Defence Infrastructure Organisation

Your Reference: EN020028
Interested Party Number: 20051172
Our Reference: DIO10056890

Application by Morgan Offshore Wind Limited and Morecambe Offshore Windfarm Limited for the Morgan and Morecambe Offshore Wind Farms Transmission Assets

This letter updates the Ministry of Defence (MOD) Safeguarding position with regard to the proposed Morgan and Morecambe Offshore Wind Farms Transmission Assets. A letter, dated 20 May 2025, setting out the MOD position was provided to the Examining Authority, which was subsequently updated by letters dated 22 September 2025 (in response to the Examining Authority's ExQ2 & commentary and questions on the draft development consent order) and 22 October 2025 (in response to Action Points arising from issue specific hearing 4). A Statement of Common Ground (SoCG) has been prepared in conjunction with both the Applicants and BAE Systems Warton; that SoCG was signed 31 October 2025.

**Figure 1.9: Selected Onshore Substation mitigation area – land south of Newton-with-Scales**

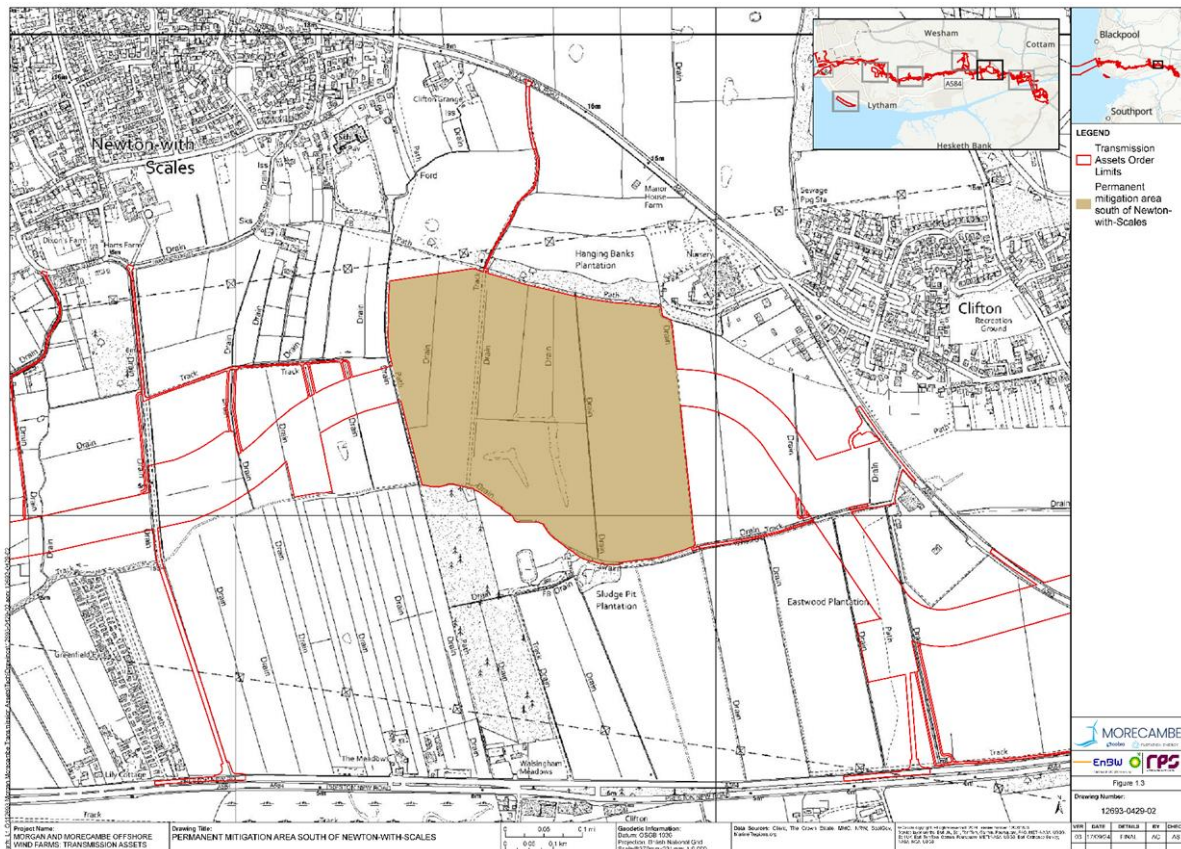
The site at Newton-with-Scales is located slightly north of Warton Aerodrome, to the south of the site is the Ribble Estuary. Given the location of the site and the Applicants' proposed enhancement of the habitat for Golden Plover, Teal, Black-tailed Godwit, other terrestrial waders such as Lapwing and Curlew, and waterfowl such as Wigeon (though the environmental mitigation proposals would also benefit breeding farmland birds such as Corn Bunting, Grey Partridge and Tree Sparrow) there is particular concern that movements of flocking hazardous birds, such as waders and waterfowl, to and from the Ribble Estuary to the south will take them through, **and across**, operational airspace which includes both the approach and take-off/climb airspace associated with runway 25 / 07. The introduction of these bird species which are hazardous to the safety of aircraft has the capacity to increase the potential for birdstrike to the detriment of aviation safety.

MOD has provided feedback to the Applicants advising that the environmental mitigation proposals, for the implementation of habitat enhancement measures to mitigate potential impacts of temporary and permanent habitat loss associated with each of the onshore substations, are not appropriate at the Newton-with-Scales location. The species targeted by these proposals include Golden Plover, Teal, Black-tailed Godwit, other terrestrial waders such as Lapwing and Curlew, waterfowl such as Wigeon, and breeding farmland birds such as Corn Bunting, Grey Partridge and Tree Sparrow. The primary objective of the mitigation area is to provide permanent alternative habitat for non-breeding Golden Plover due to the permanent habitat loss at the onshore substation sites. Golden Plover form very dense flocks, and movements of these flocks around the area to the east of Warton Aerodrome will have a significant impact on birdstrike risk with this species (flocking species result in a higher probability of damage to the aircraft if struck due to the increased chance of multiple strikes in the same incident).

During discussions MOD has advised that use of the Newton-with-Scales site for the species identified is problematic. If it is necessary to provide habitat for these species it would be more expedient and/or judicious to provide it on a site south of Warton Aerodrome, ideally to the south of the estuary. If mitigation must be undertaken at the Newton-with-Scales site it should target less potentially hazardous species such as Corn Bunting and Grey Partridge and be designed to deter larger more hazardous species especially wintering waders and waterfowl.

Figure 1-1: Environmental mitigation areas at south of Newton-with-Scales

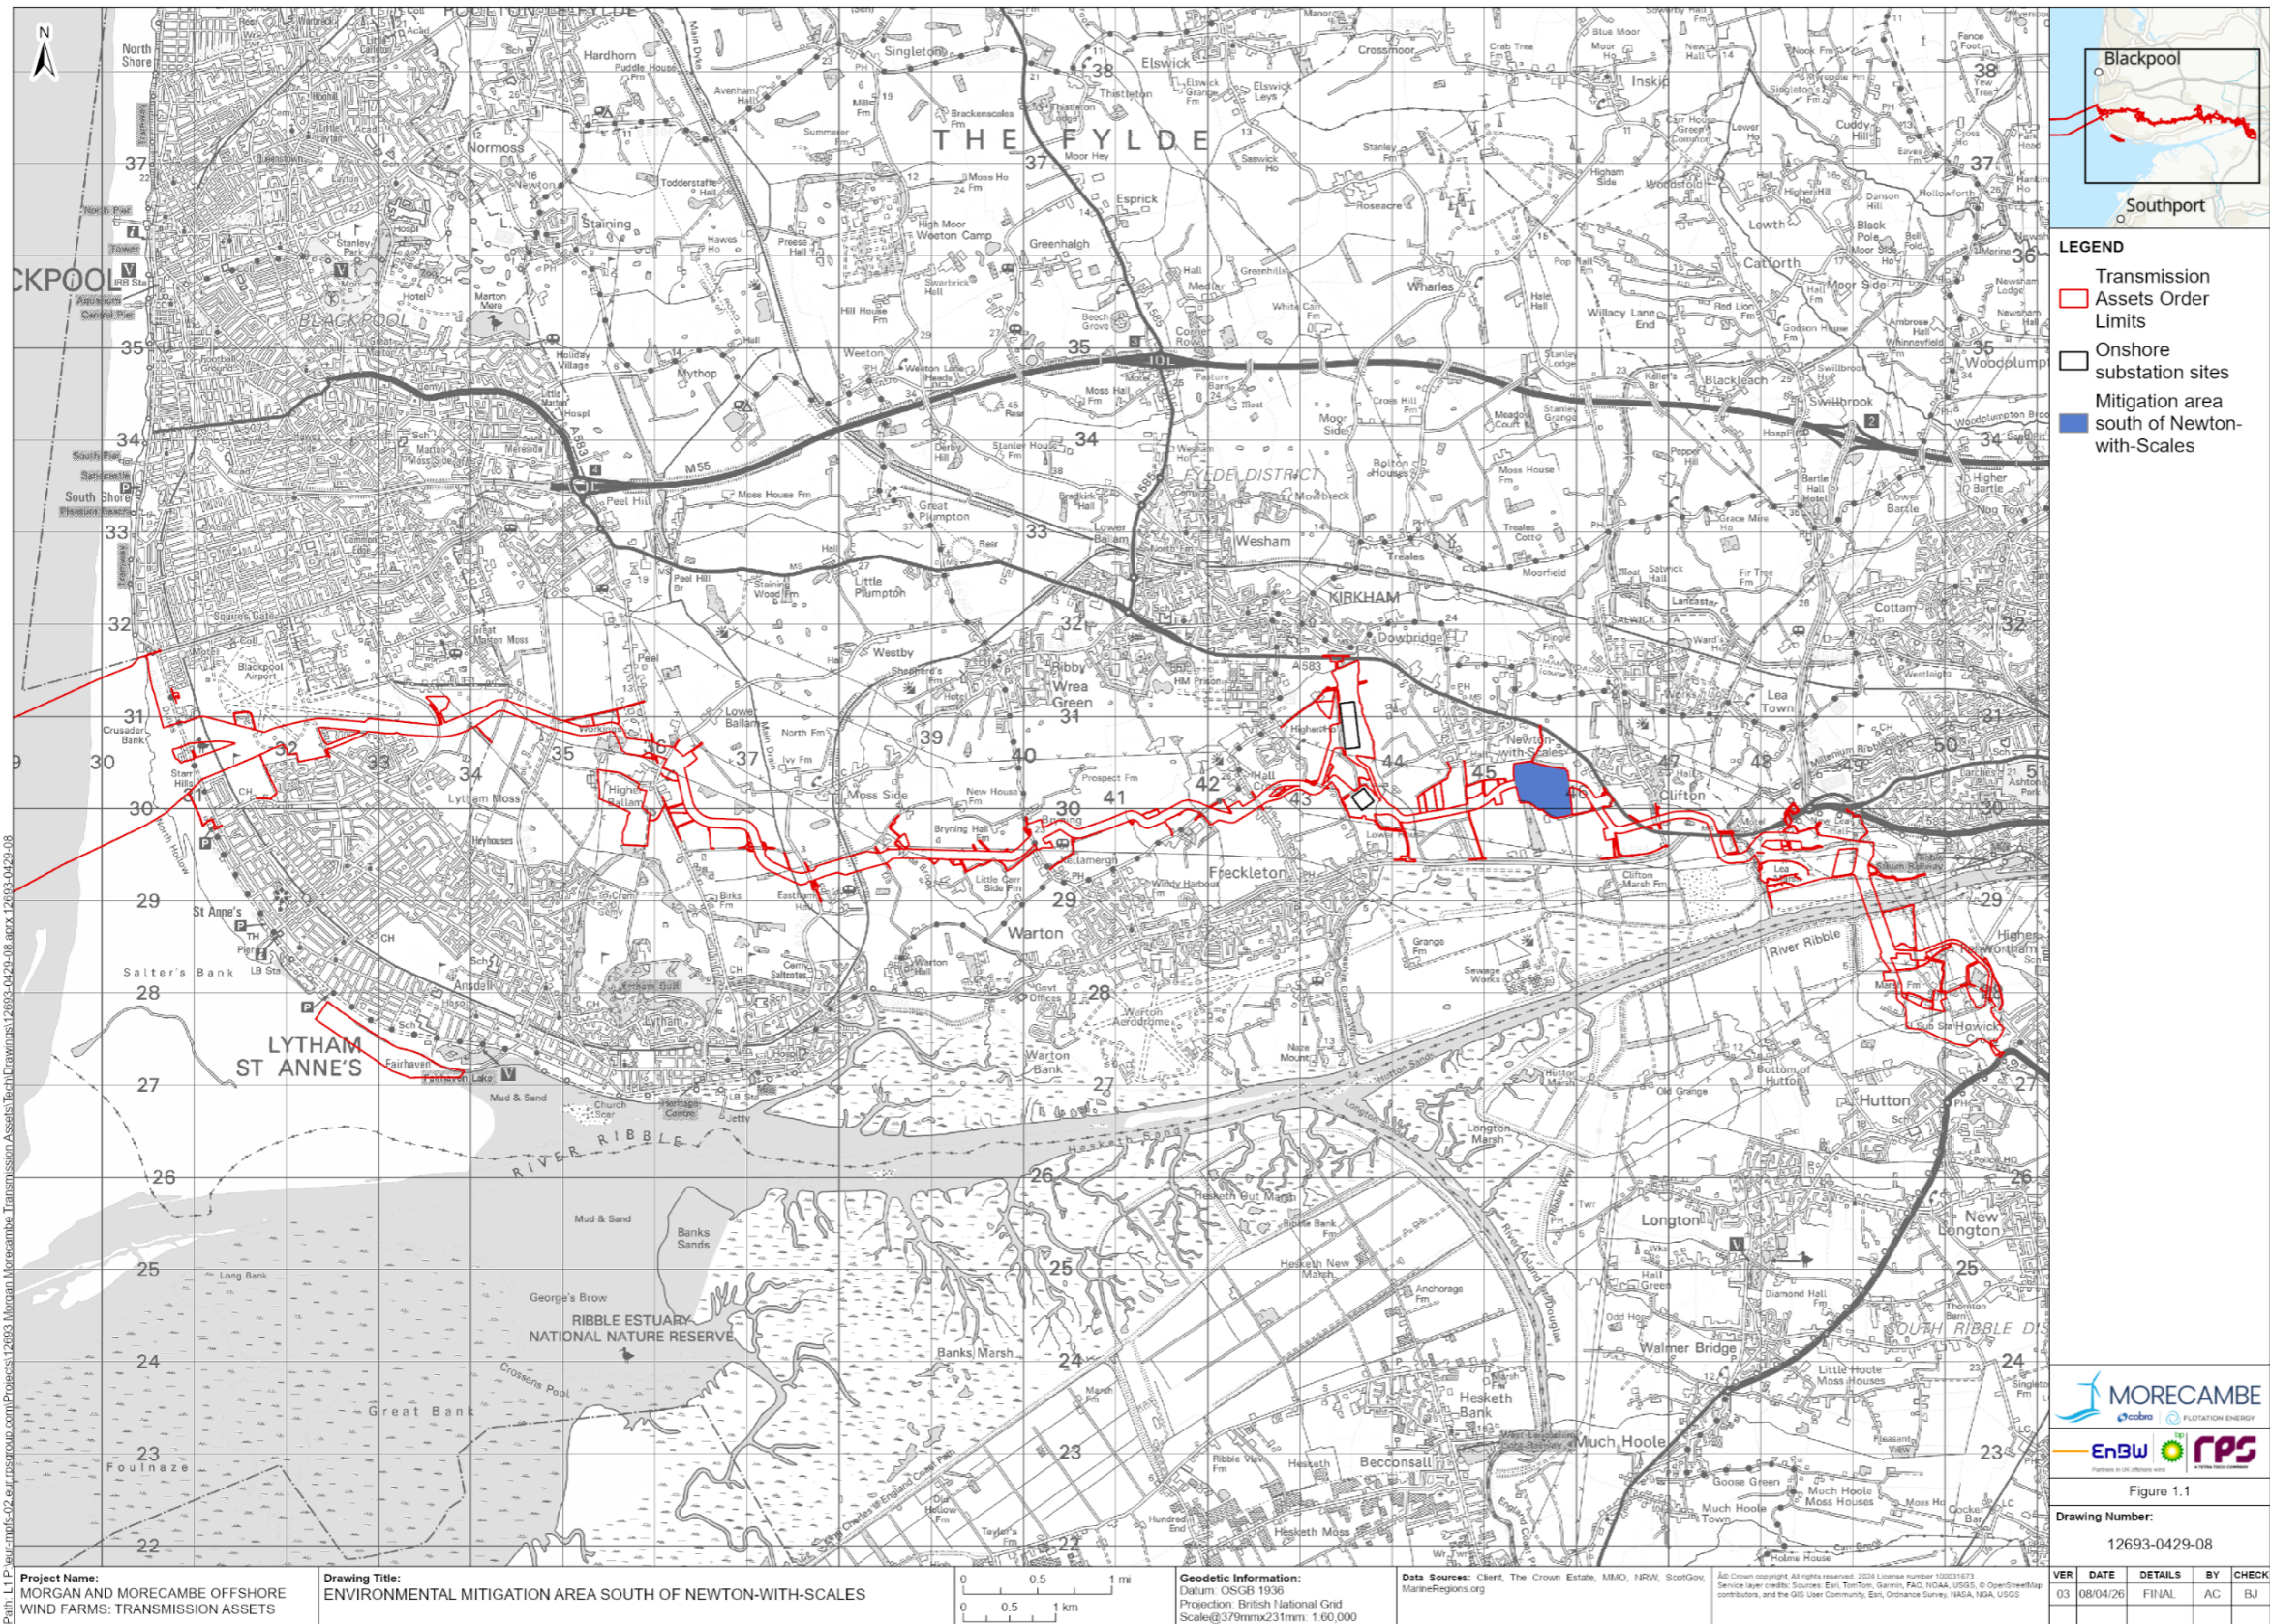
Work Numbers 49A (Morgan permanent environmental mitigation works including permanent access) and 49B (Morecambe permanent environmental mitigation works including permanent access) relate to proposed works covering a variety of sites. These works at Newton-with-Scales involve the enhancement and restoration of existing habitat features to provide replacement habitat for non-breeding and breeding terrestrial waterbirds and farmland birds displaced by the permanent loss of habitat at the sites where the onshore substations will be located. Amongst the environmental measures and activities to be undertaken at Newton-with-Scales the Applicants propose the creation of permanent scrapes, management water levels within existing ditches, stopping up hedgerows and the creation of a mosaic of grassland.

The MOD is advised that any effective management plan to mitigate the potential birdstrike risk associated with the proposed environmental enhancements would be, by design, required to target those species for which the Applicants seek to provide a replacement habitat. For a management plan to be effective in mitigating the potential increase in birdstrike risk it would need to ensure that no

hazardous birds are utilising the Newton-with-Scales site above the levels that are currently present there.
